Appeal Decision

Appeal Ref: APP/R5510/W/21/3277296

84 East Road, West Drayton UB7 9HA

- The appeal is made under section 78 of the Town and Country Planning Act 1990 against a refusal to grant planning permission.
 - The appeal is made by Mr & Mrs Agrawal against the decision of the Council of the London Borough of Hillingdon.
 - The application Ref 31005/APP/2020/3975, dated 1 December 2020, was refused by notice dated 27 May 2021.
 - The development proposed is described as, "New Dwelling House".
-

Drawing Title  
**PROPOSED NEW  
DWELLING**

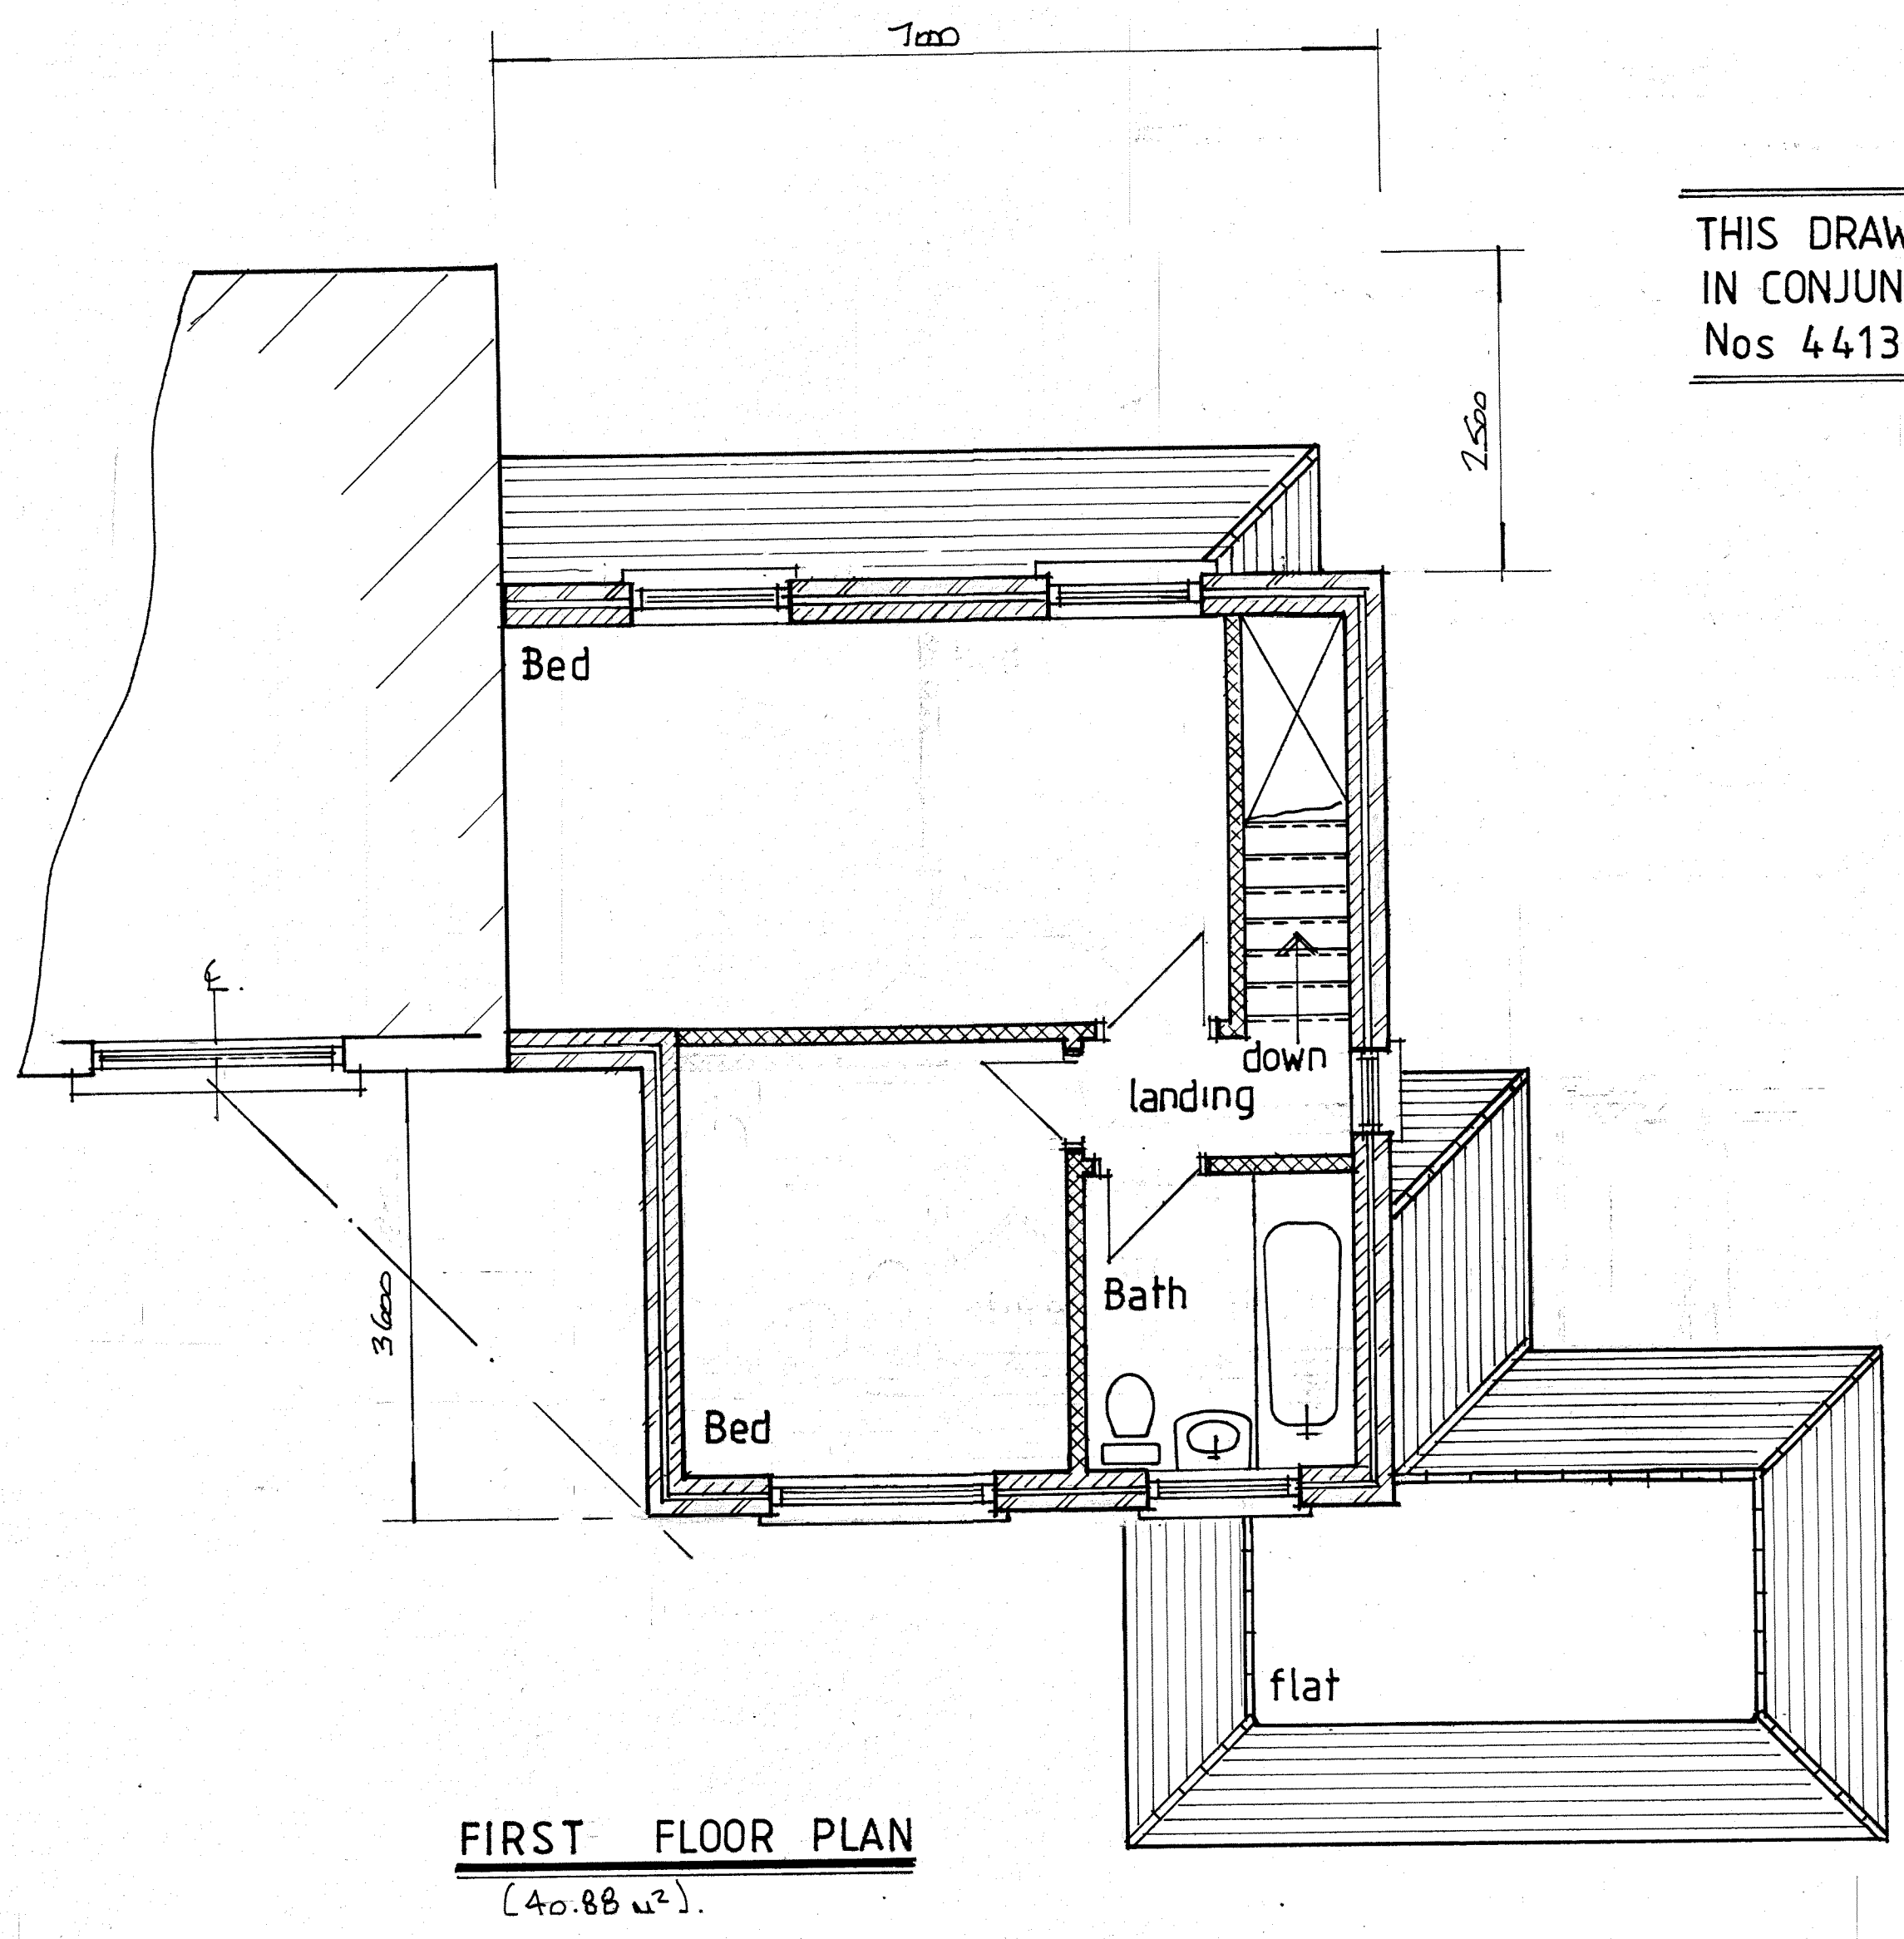
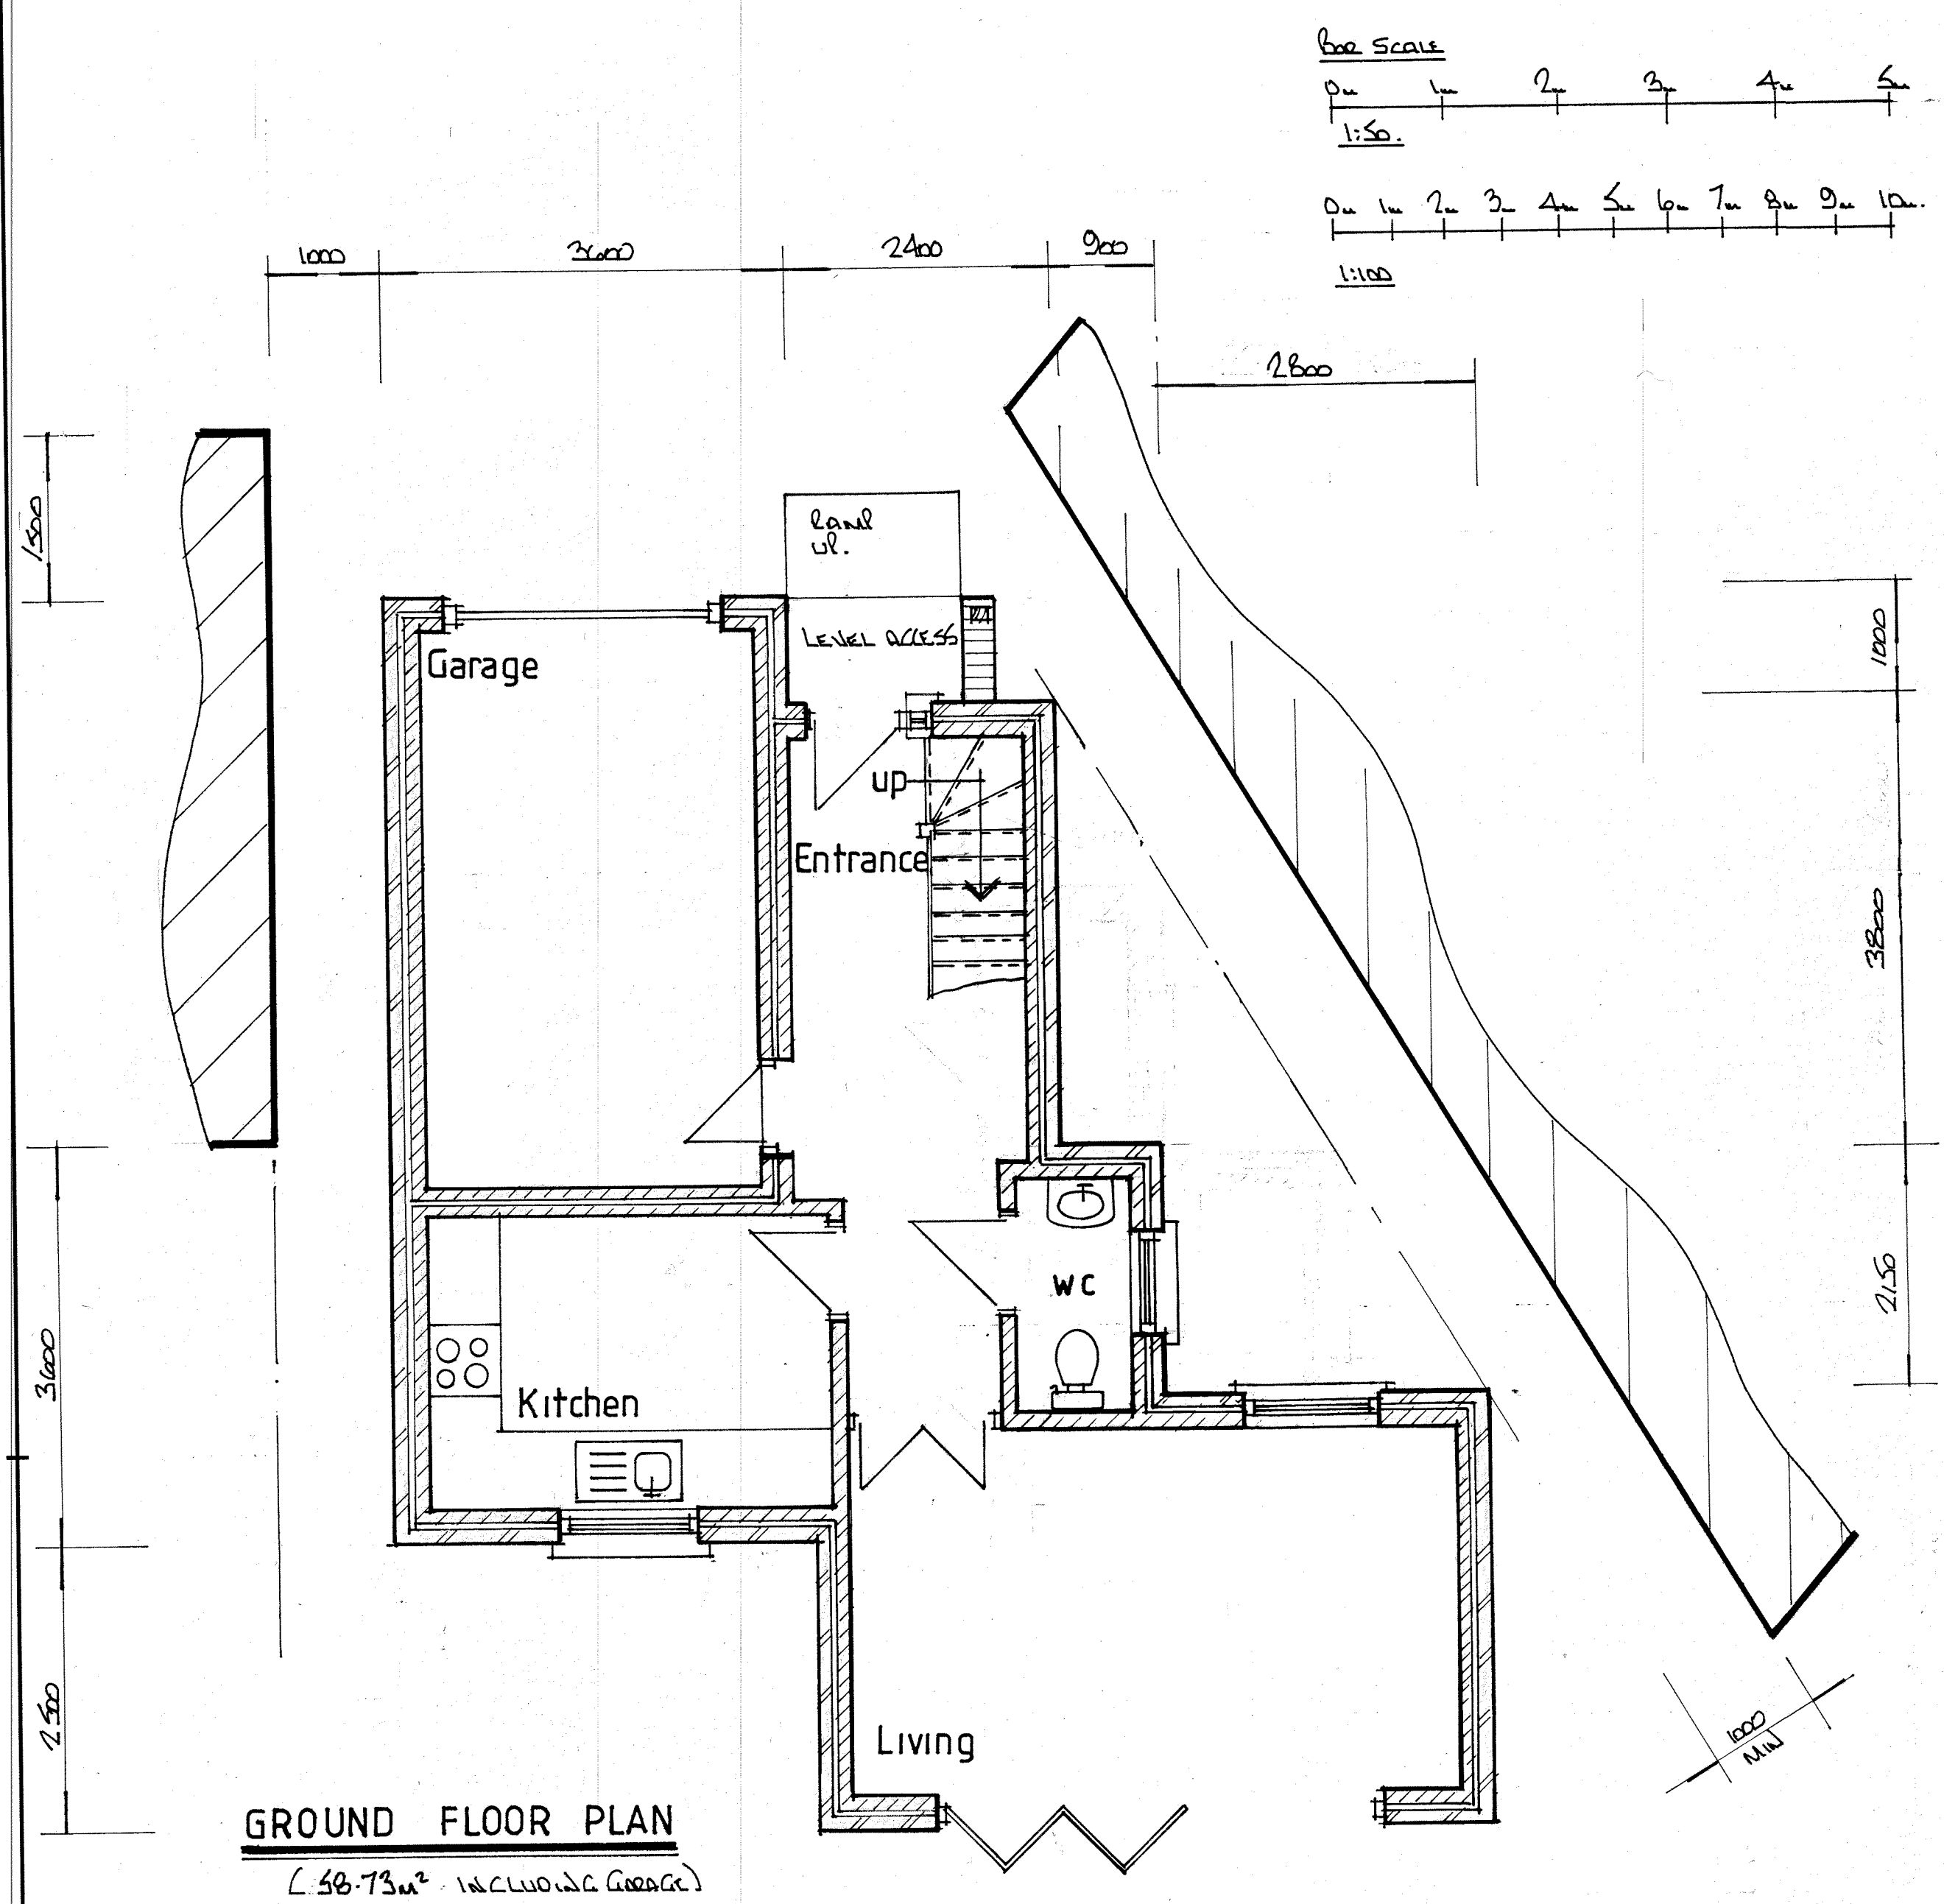
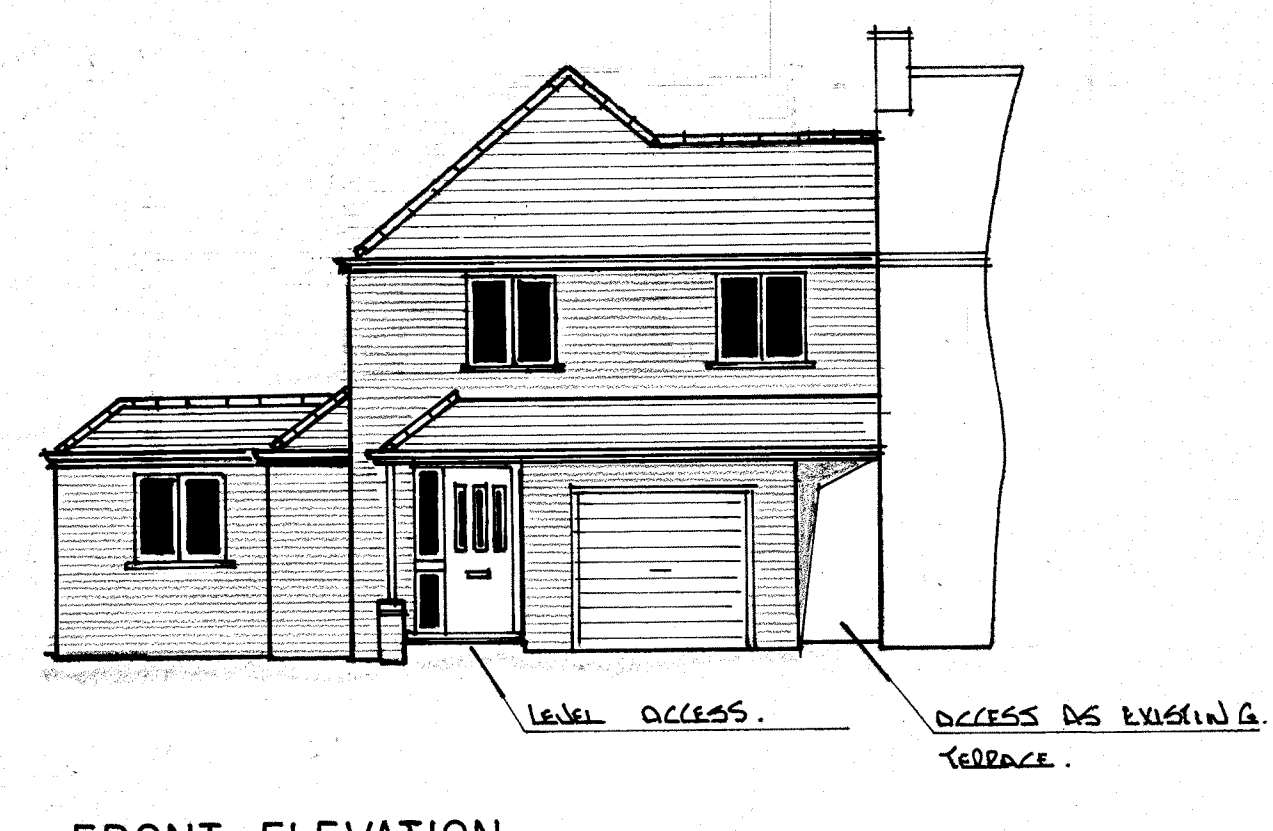
5. Nevertheless, the proposed dwelling would project very close to the existing single-storey side projection at No 86, thereby removing the majority of the pockets of small visual gaps that presently exist between Nos 84 and 86 at ground-floor level. More importantly, although it would not completely erode the existing gap between Nos 84 and 86 at first-floor level, it would subsume a substantial portion of that gap. As such, the proposal would unduly reduce the sense of spaciousness referred to above. Moreover, the proposed hipped roof, with its lower 'link' detail, would appear incongruous in the street scene considering the absence of this feature on many nearby properties. Taking all this into account, the proposal would cause material harm to the character and appearance of the area.
